Applicant's comments on Deadline 2 Submissions

PINS Reference Number: EN010069

Deadline 3 – 21 December 2018

2 REP2-012 City and County of Swansea

HEDGEROW PLAN

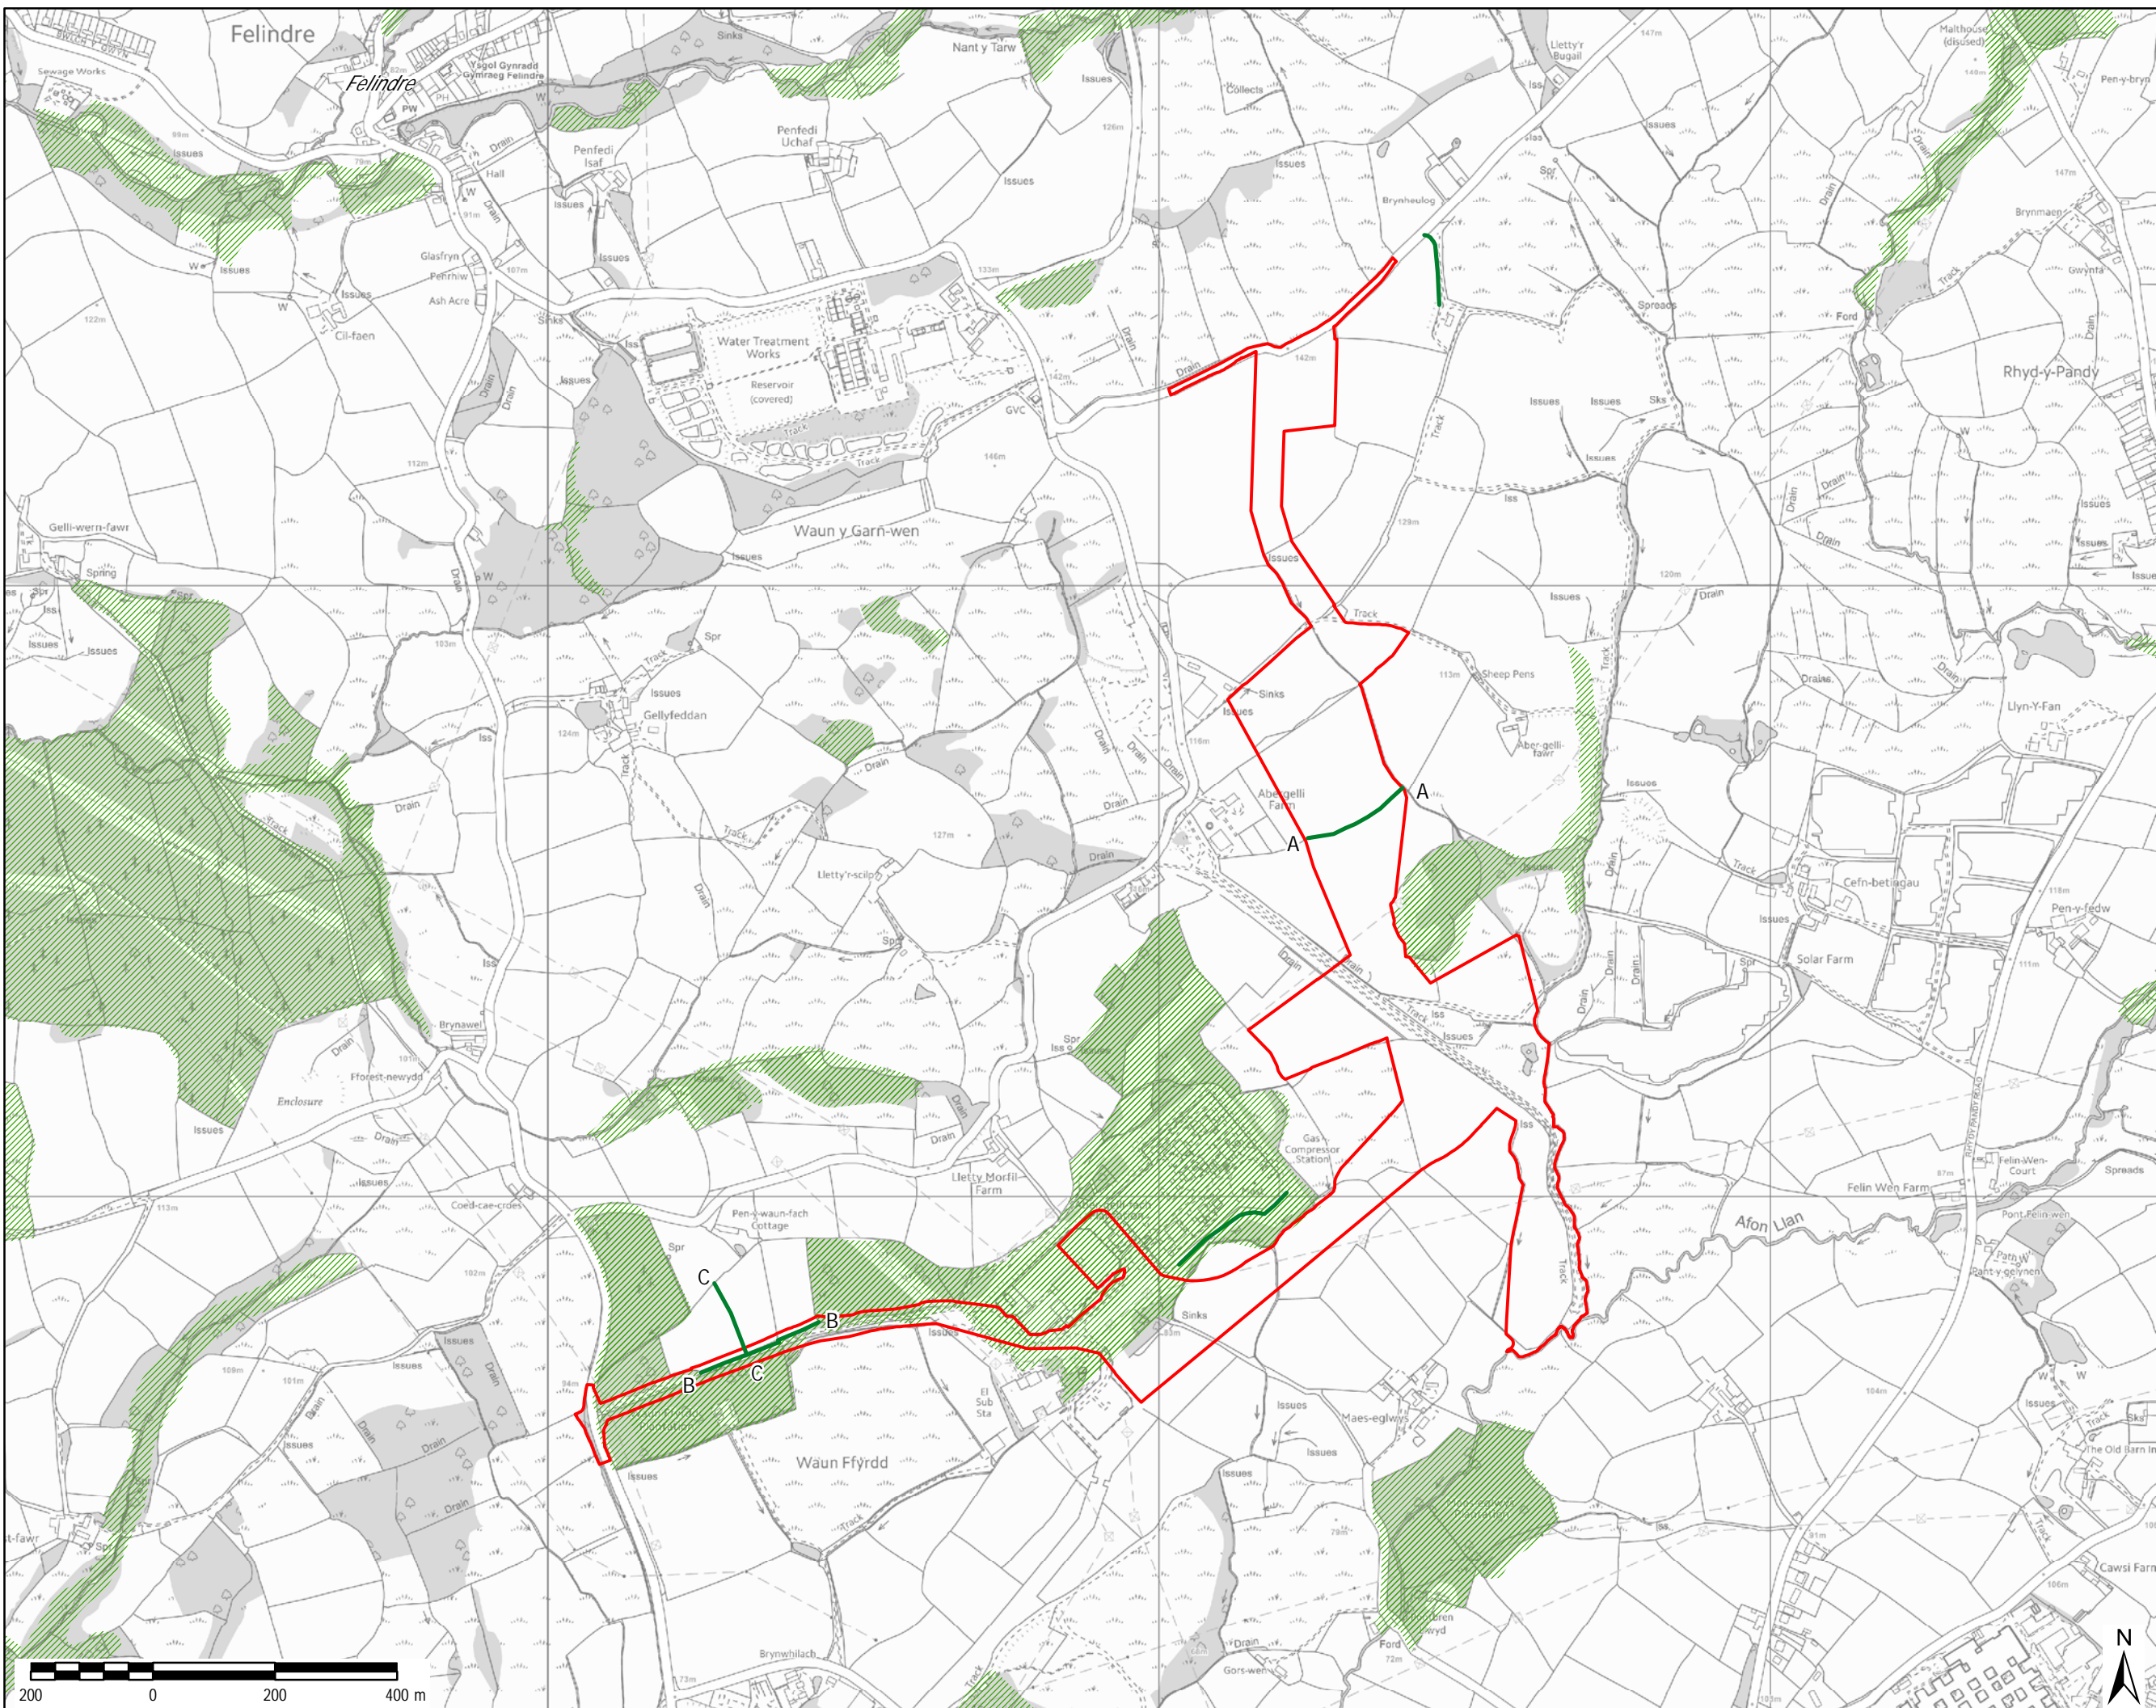
Appendix D Article 35 – removal of hedgerows	CCS consider that mitigation planting for these works should include mitigation measures for the loss of habitat. It is also suggested that checks should be undertaken for bats prior to any works and necessary provisions built in to the Article in the event that bats are found to be present (e.g. mitigation/ method statement and licenses).	Refer to 11.47, 11.50 and 11.53 of the Applicant's response to CCS' Local Impact Report, and to 1.6.5 of the Applicant's Response to the CCS' responses to the First Written Questions. The article 35 power (to remove hedgerows) is already subject to the requirements in Schedule 2, as are all works and activities permitted by the Draft DCO. Therefore no amendments are required to article 35 or the requirements since the latter already provide the protections sought by CCS in article 35.
Appendix D Requirement 5 – fencing and other	It is suggested that clarification is included in this Requirement to ensure that all fencing (temporary and permanent) is 'wildlife friendly'. As stated elsewhere in the application, access should	The Applicant has to comply with specified security parameters for certain fences, and those will not therefore be 'wildlife friendly'. Other fences can be designed to accommodate appropriate wildlife.

Reference	Summary of points made by CCS	Applicant's Response
means of enclosure	be allowed for various species and clarification in this point will ensure that it is not overlooked at a later date if considered in isolation.	It would not therefore be appropriate for wildlife friendly fencing to be a blanket requirement across the Site. The Applicant will discuss this further with the Council and consider amendments to the Draft DCO for Deadline 4.
Appendix D Requirement 6 – Surface and Foul Water Drainage	It is queried whether Work Nos. 2, 3 and 5 will actually have a foul drainage plan and if not, whether this requirement can be discharged given the current wording of the Requirement. Work No.	Whilst Work Nos. 2, 3 and 5 will not have foul drainage required for them specifically, the Applicant does not consider that Requirement 6 needs to be amended. It is a consolidated drainage requirement, and where there is a submission in relation to a Work No. which has no foul drainage, that can be briefly referenced in the submission by APL pursuant to the requirement.
